RE: PICTON HIGH SCHOOL REDEVELOPMENT (SSD 8640) SECTION 4.55 MODIFICATION 1 RESPONSE TO SUBMISSIONS

The notification of the Modification for the Picton High School Redevelopment (SSD 8640) ended on 1 March 2019. One submission from Wollondilly Shire Council was received by the Department of Planning and Environment (DPE) during notification of the project.

SGN - 115A

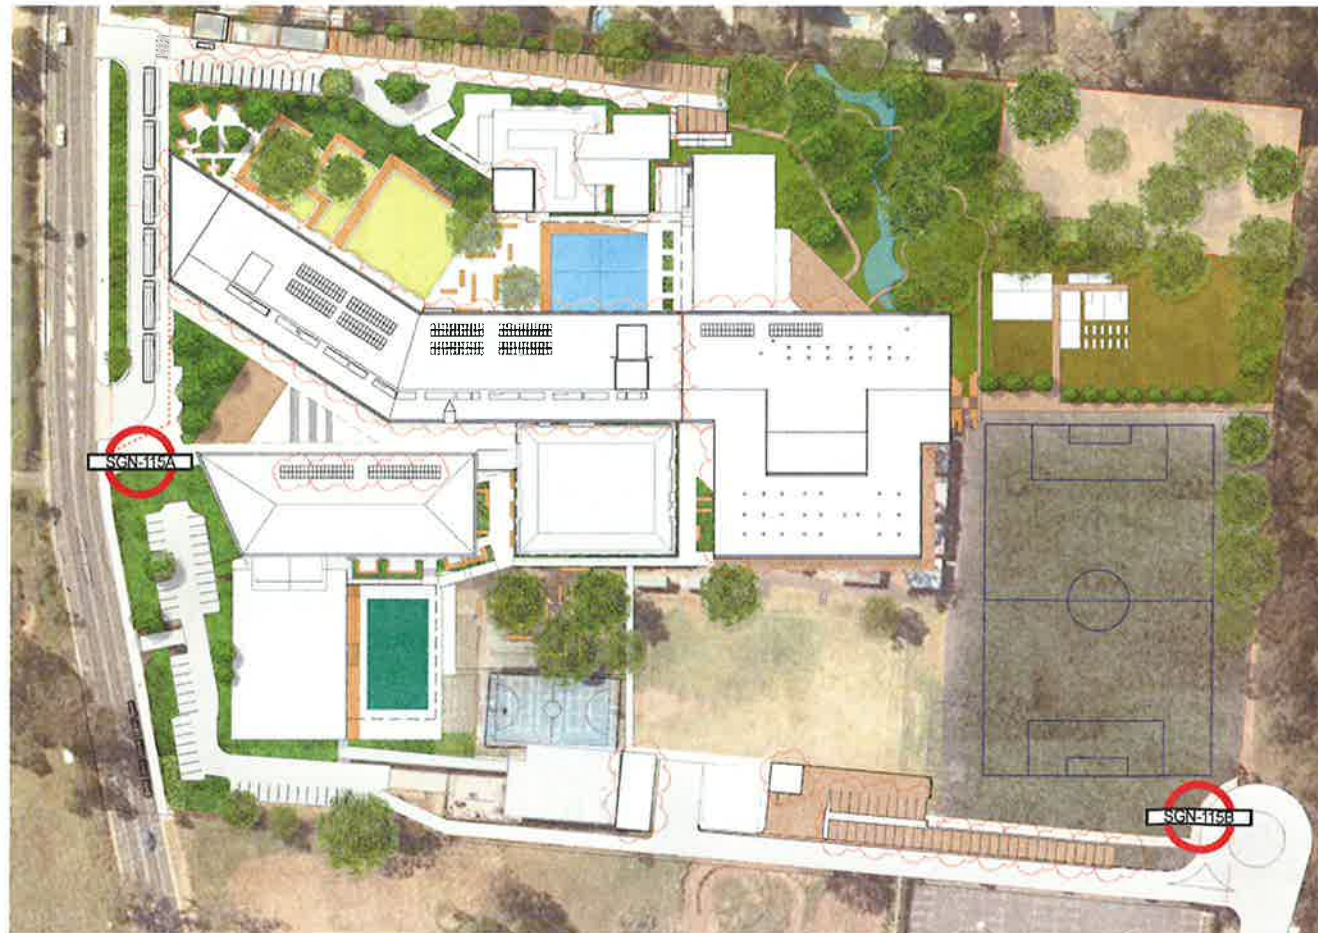
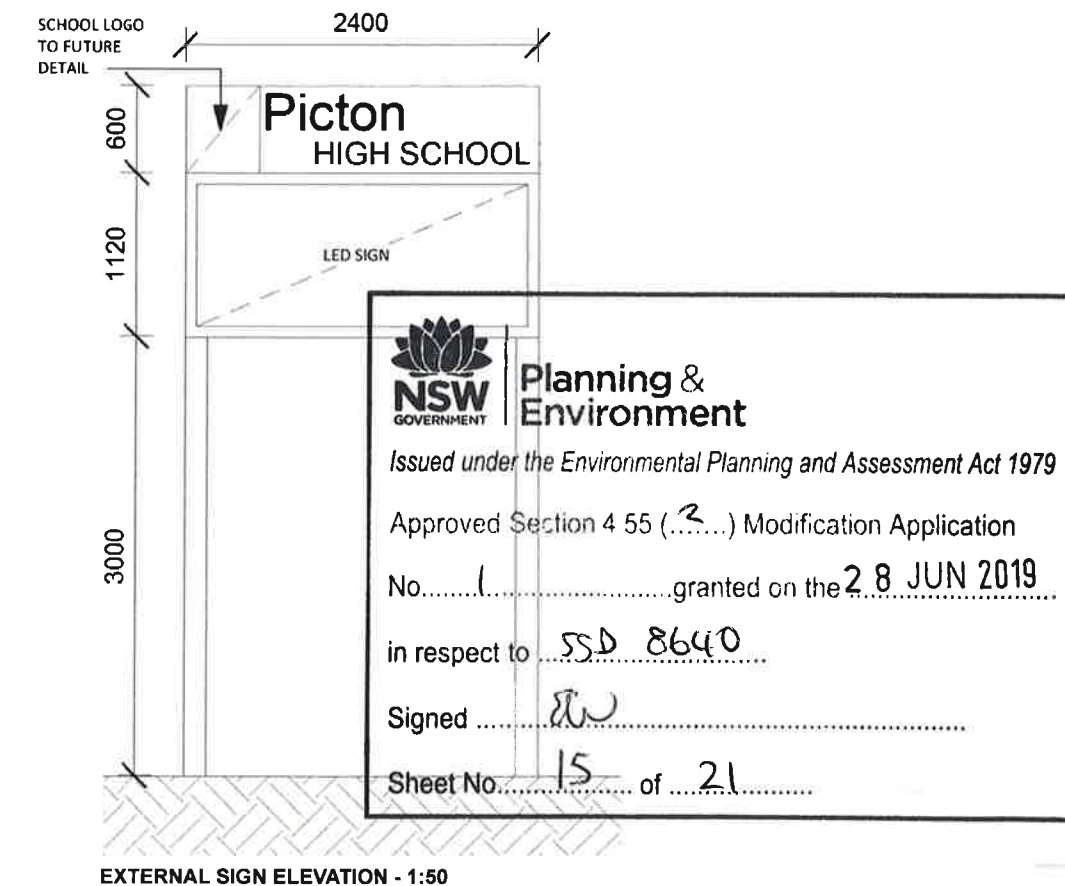
The DPE notes that the dimensions/details of the two signs proposed to be installed are provided with the application, however, no dimensioned plans corresponding to these dimensions/details have been submitted.

Architectural plans detailing dimensions and details of the proposed signs have been prepared by BLP and are available at **Attachment A**. An elevation of the proposed signage including dimensions as replicated from the plans is shown below in **Figure 1**.

SOFTSCAPE | TREE SIZE SPECIFICATION & FORMAL SOFTSCAPE AREAS

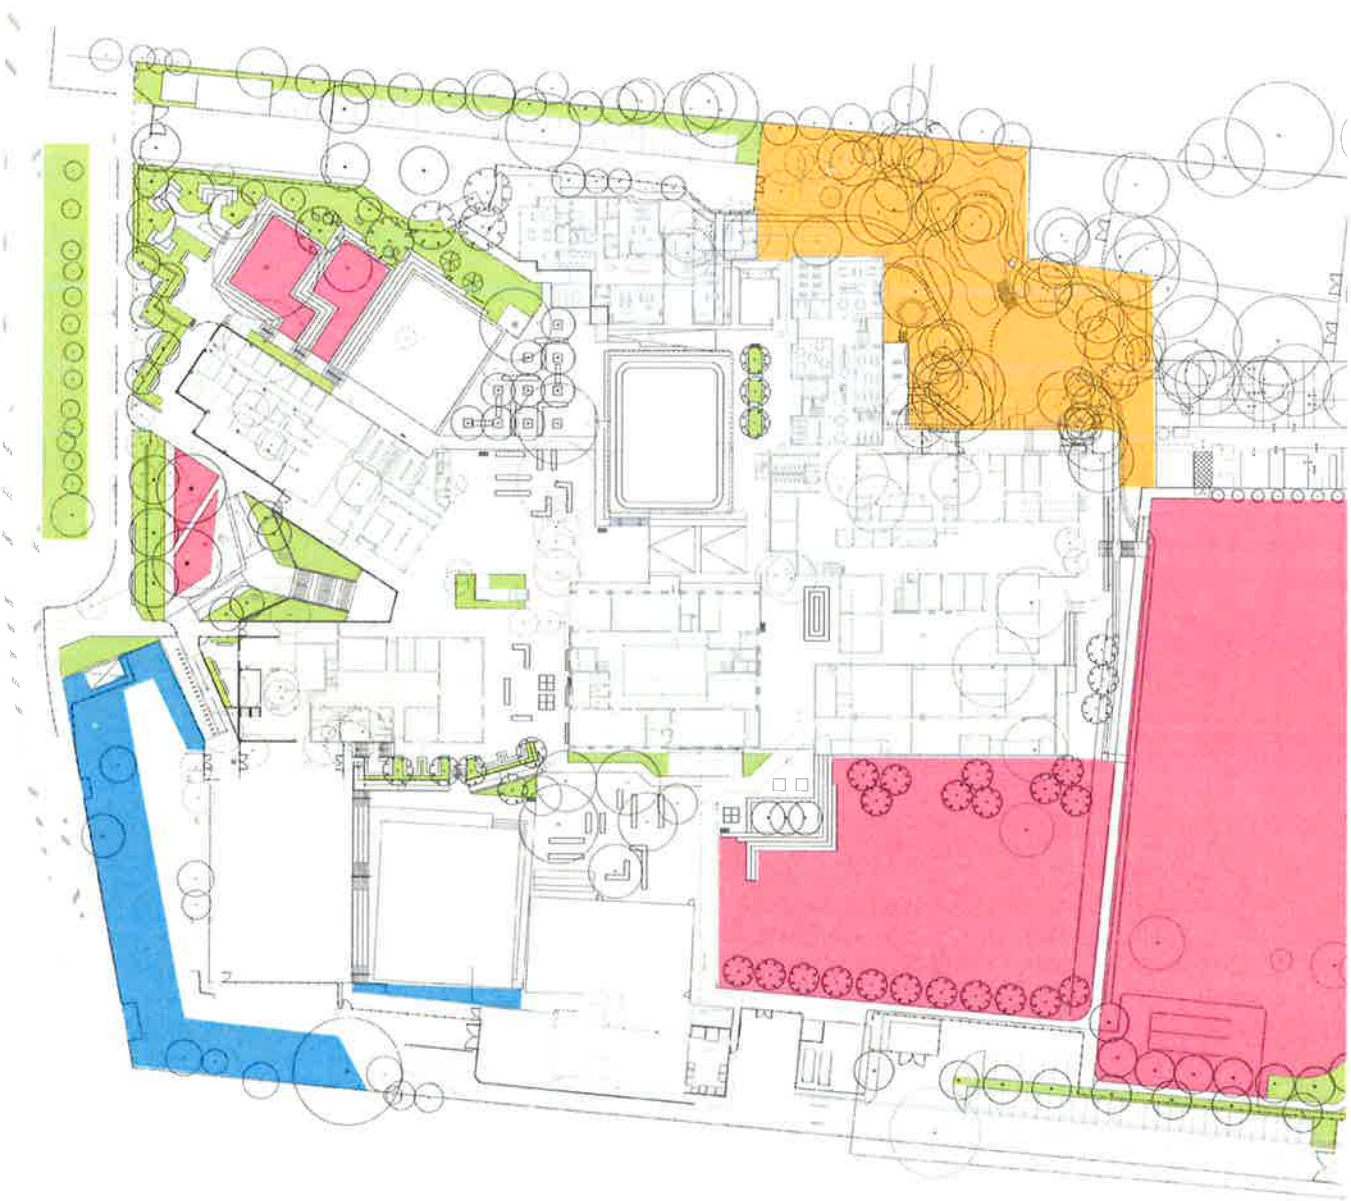
The DPE has requested a revised 'Tree Size Specification & Formal Softscape Areas' plan is to be submitted reflecting the removal of the additional trees and relocation of four proposed trees.

The updated plan is provided at **Attachment D**.

DESIGN | TREE RETENTION + REMOVAL STRATEGY

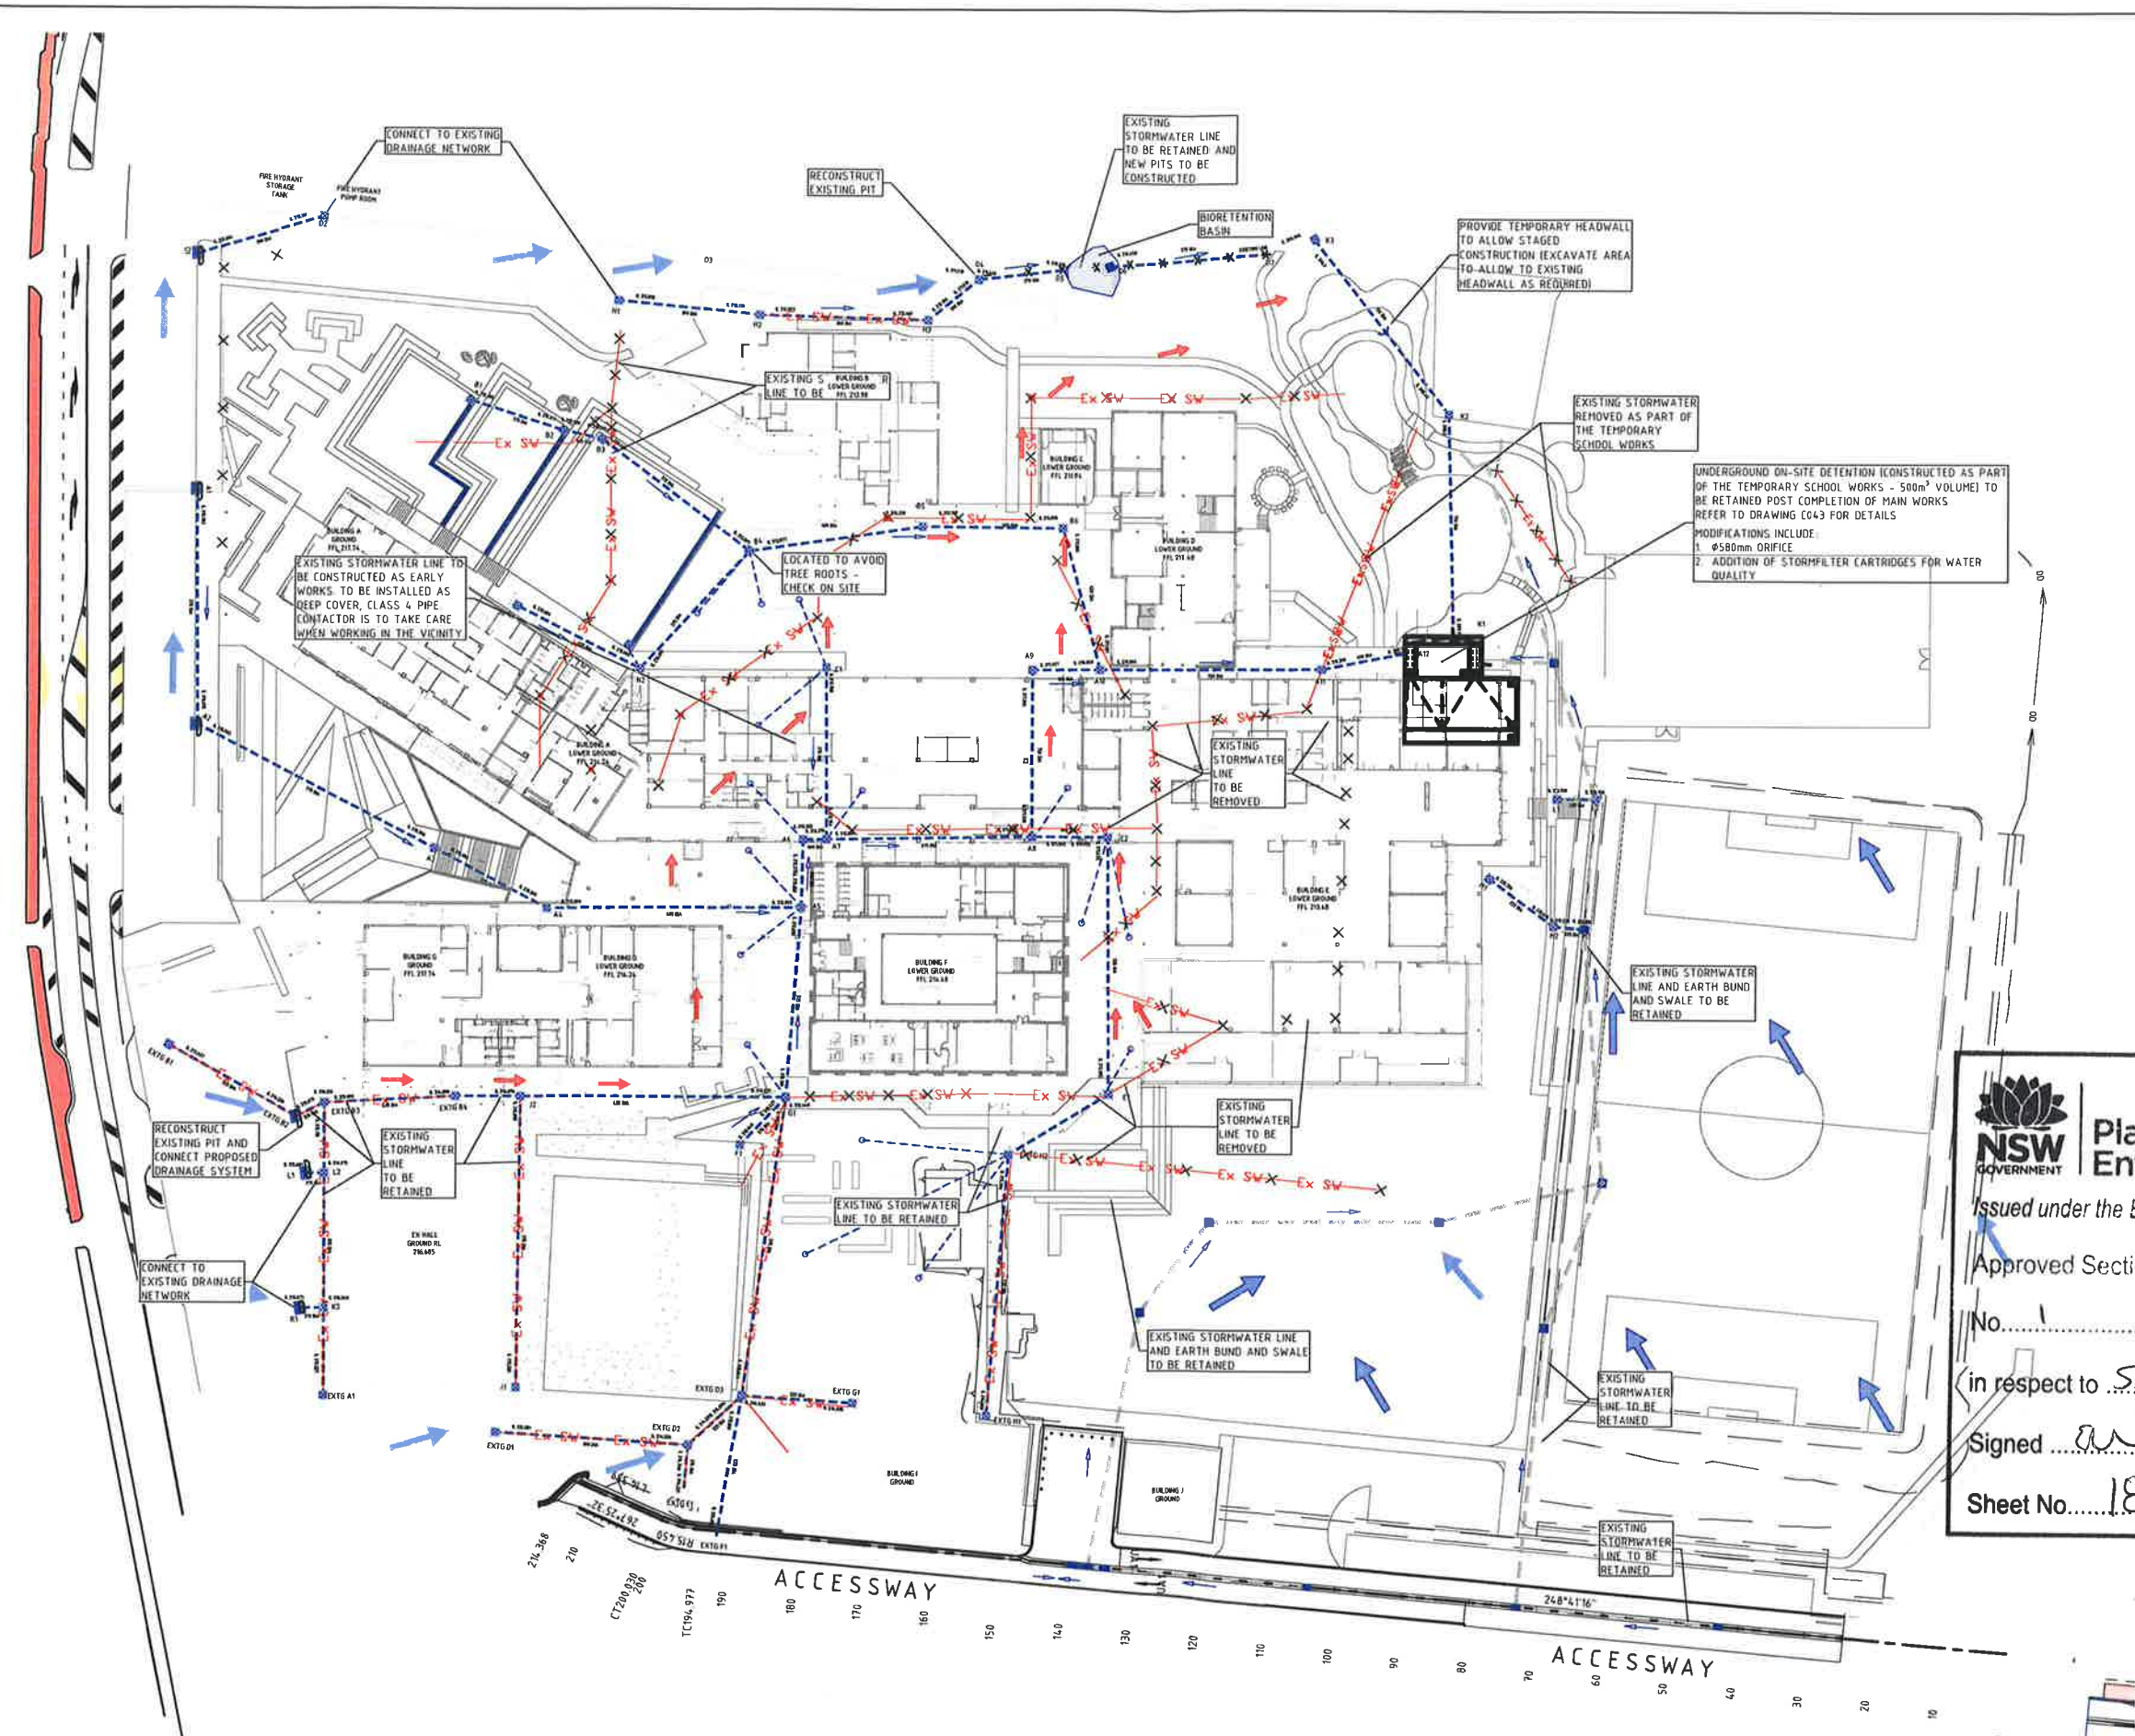
The DPE is requesting clarification for a tree on the southern side of the main building which is proposed to be removed under the Tree Retention and Removal Strategy submitted with the Section 4.55 Application.

We confirm the tree, which is identified as Tree 66 in the Arboricultural reports, is proposed to be removed under this application. The removal of this tree is required following further consideration of the construction impacts of the redevelopment. Its removal is not specifically triggered by works proposed as part of the Section 4.55 Application.
